From: [Holly Duncan](#)
To: [Dusty Pilkington](#)
Subject: RE: VA-16-00001 Mostofi Variance
Date: Tuesday, September 13, 2016 12:47:11 PM

[VA-16-00001 Mostofi Variance](#)

VA-16-00001

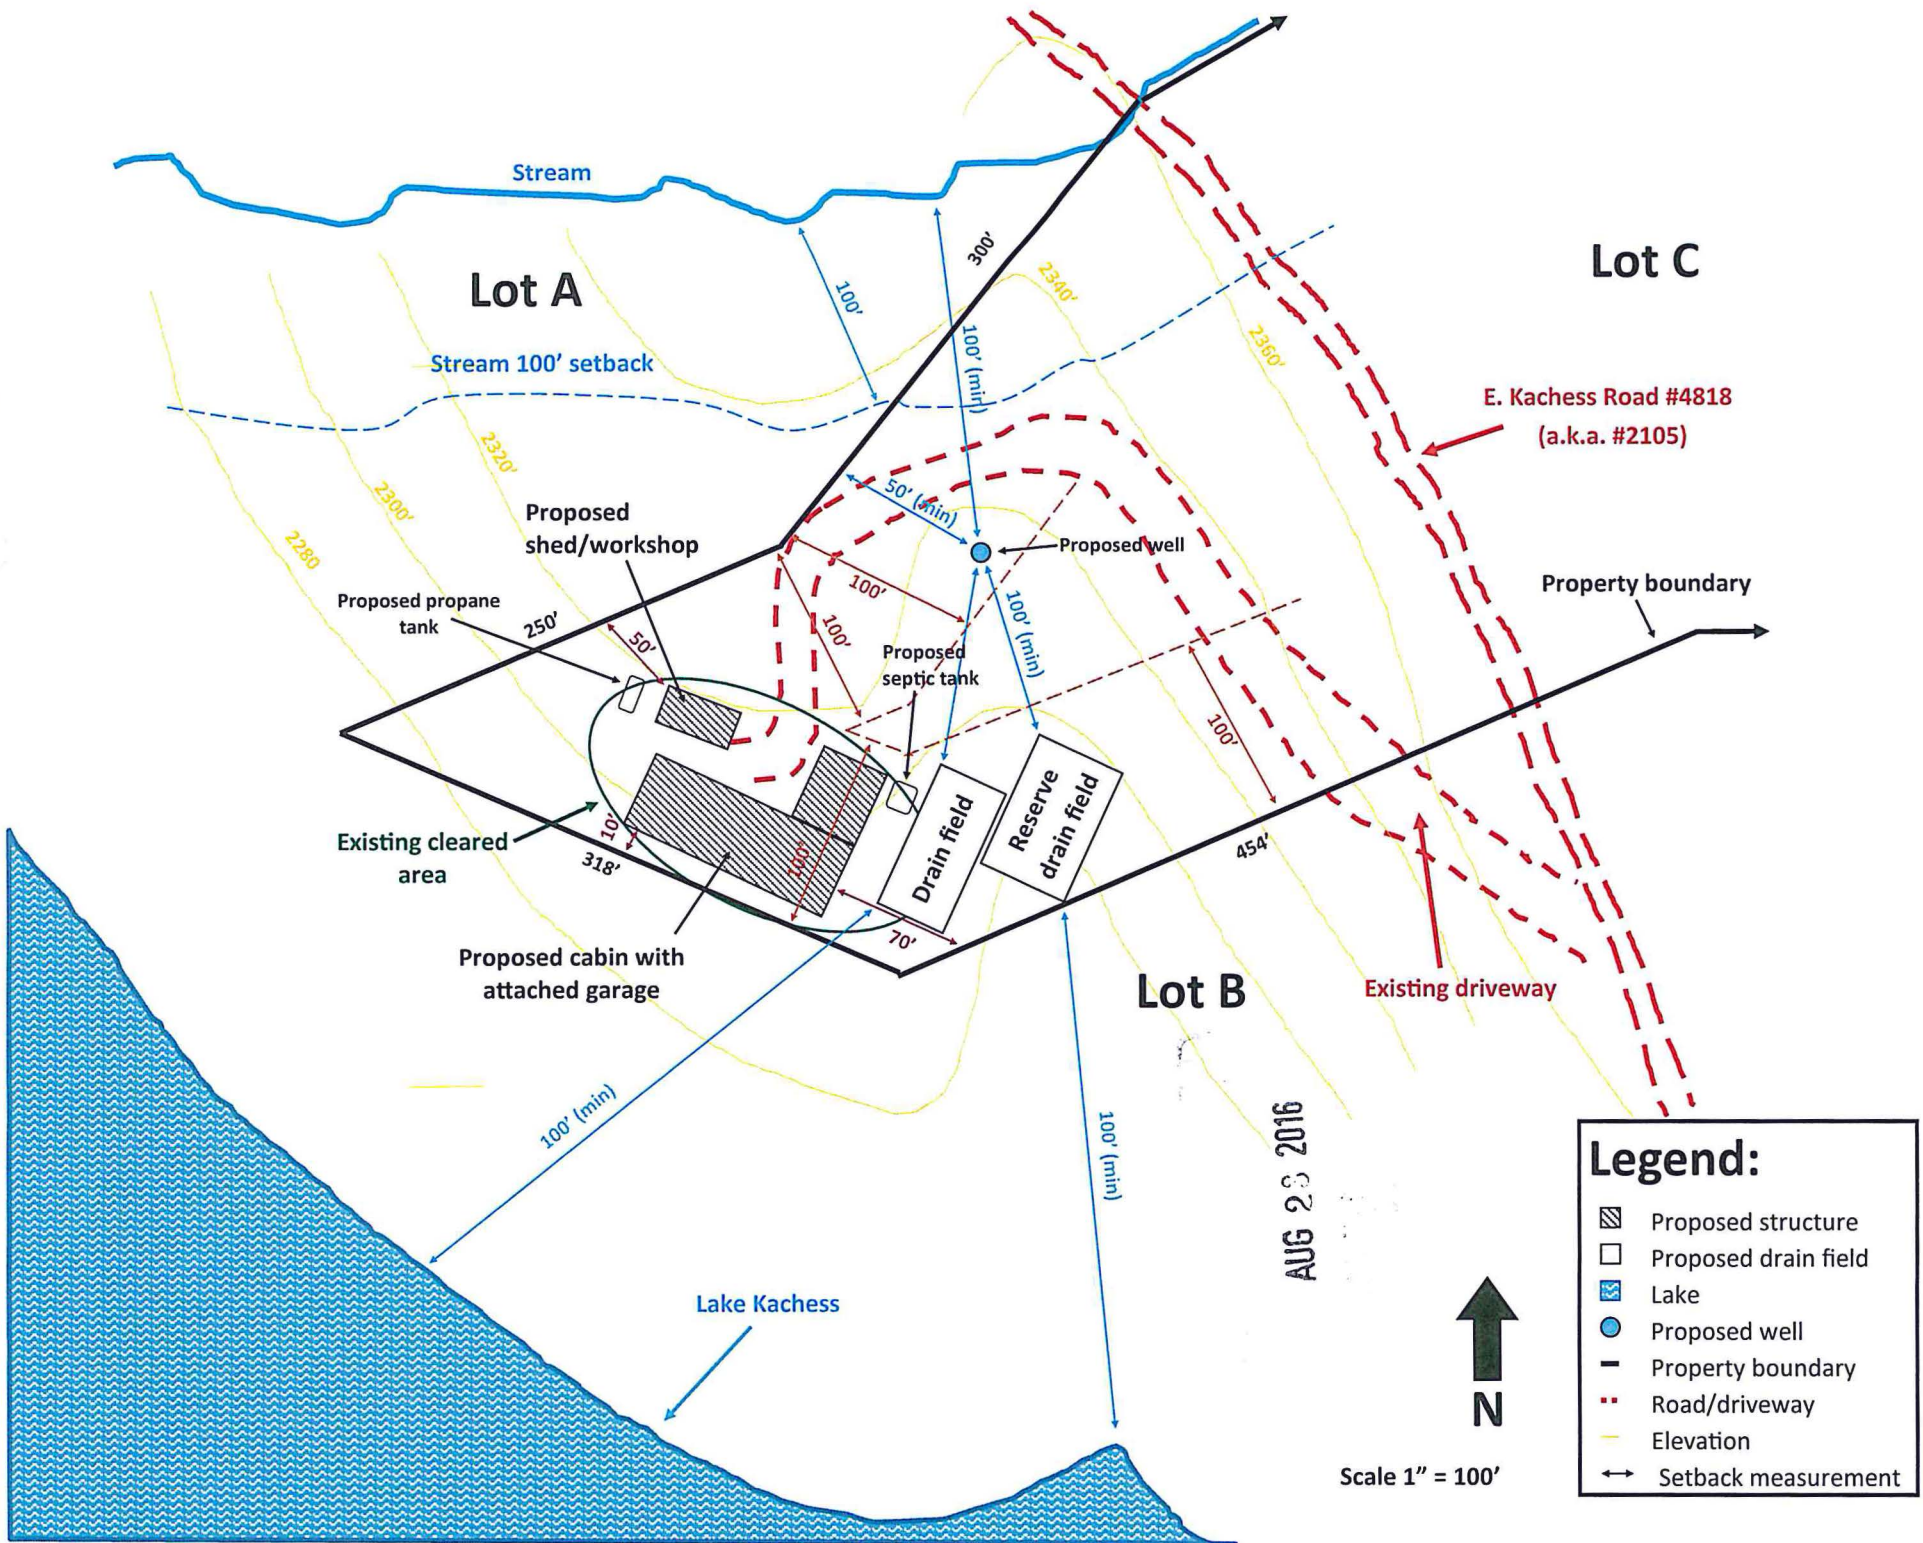
My only concern on this property is the grade. Getting a well drilling rig onto the property may be challenging and a drainfield cannot be installed on slopes greater than 30%.
